# **FENWICK SOLAR FARM**

**Applicant's Summary of Oral Submissions at the Issue Specific  
Hearing (ISH3) on Environmental Matters and Post Hearing  
Notes**

**Document Reference: EN010152 /APP/8.33**

**AECOM**

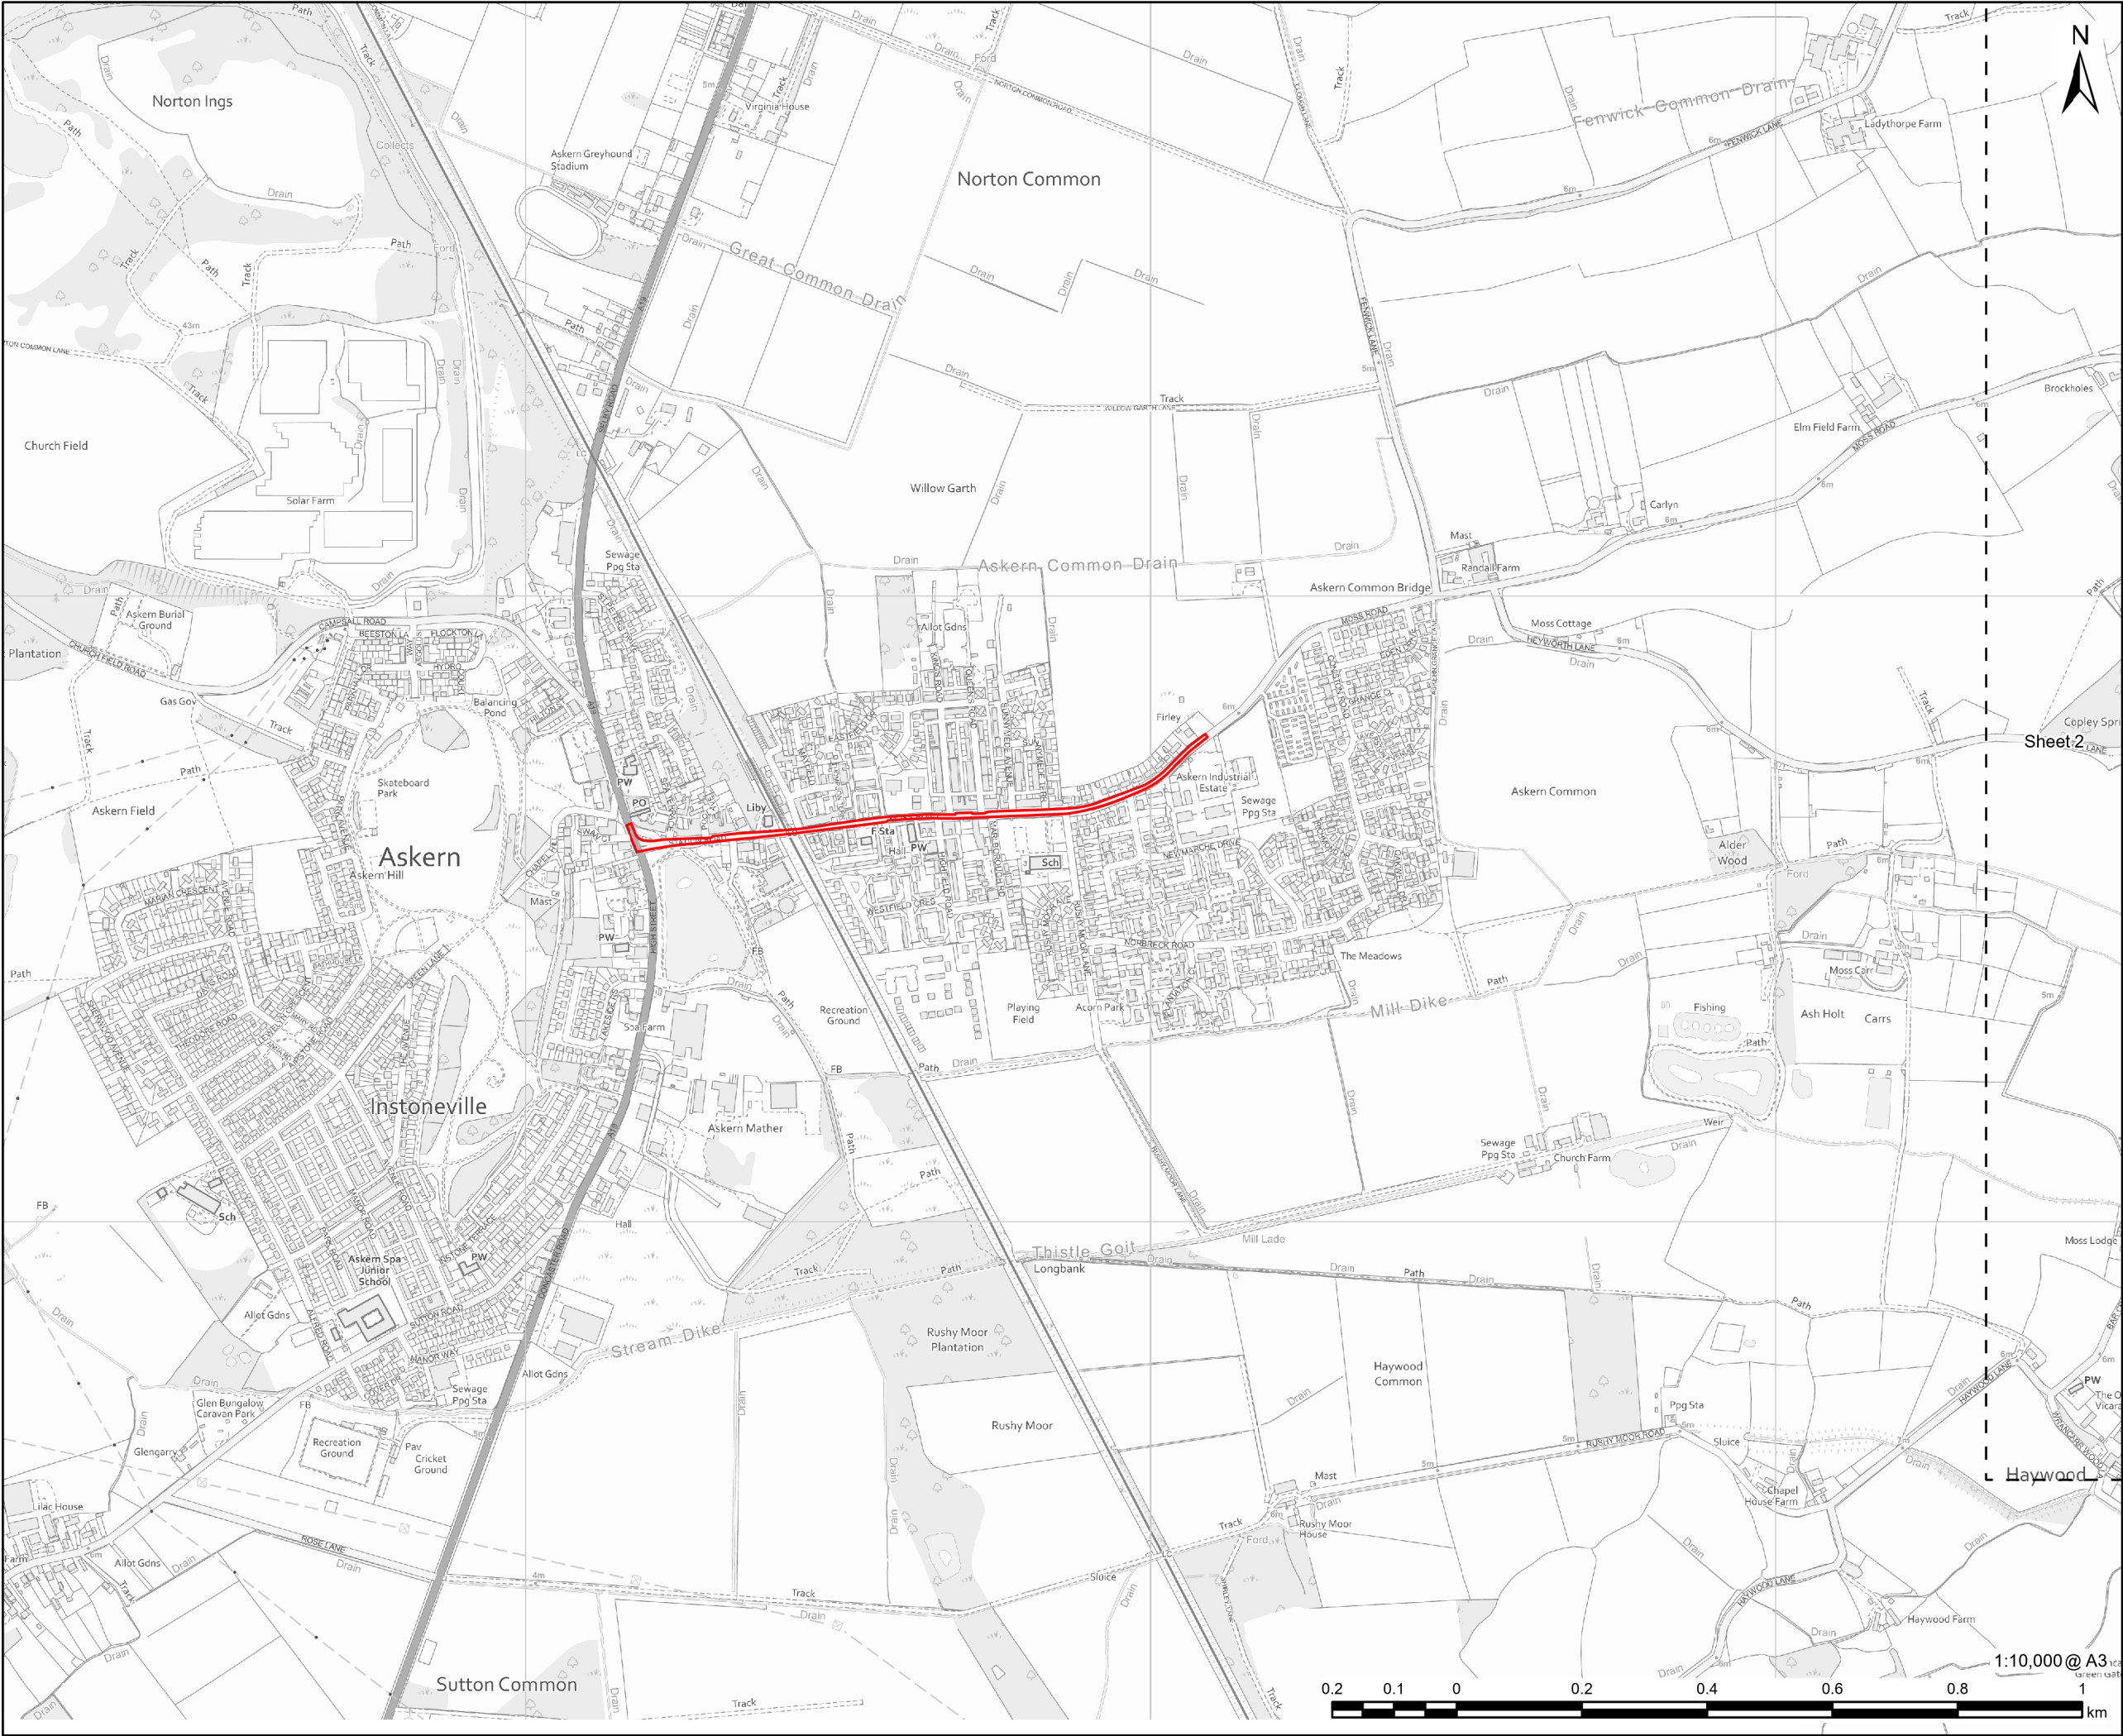
With reference to Annex A of the Hedgerow Report [APP-150], Mr Gates, then provided further details as to the current status of proposed works with particular reference to hedgerows H114a, H115a, H115b, H116a, H121 and H132. The Applicant confirmed that they would submit updated plans at Deadline 3 showing the current predicted areas of hedgerow loss.

The ExA enquired as to why hedges H83 and H96 are not classified as important within the Order Limits.

**Post hearing note:** Figure 8.5.2 [EN010152/APP/6.3] has been updated to reflect the hedgerow removal discussed at ISH3. In particular, the Applicant can confirm that H114a will be subject to a small area of loss at the east end for construction access, which will be re-instated upon completion, but that the loss previously shown in the central section will no longer occur. There will be no loss to H116a.

**Post hearing note:** With reference to Figure 8.5.2 [EN010152/APP/6.3], the Applicant can confirm that neither H83 nor H96 are classified as Important Hedgerows. Figure 8-3 UKHab Plan [APP-094] shows that as H83 and H96 meet the Order Limits, they are no longer classified as hedgerows, but instead as 'w1h - Other woodland; mixed - 29: Plantation' and 'Individual Tree'.
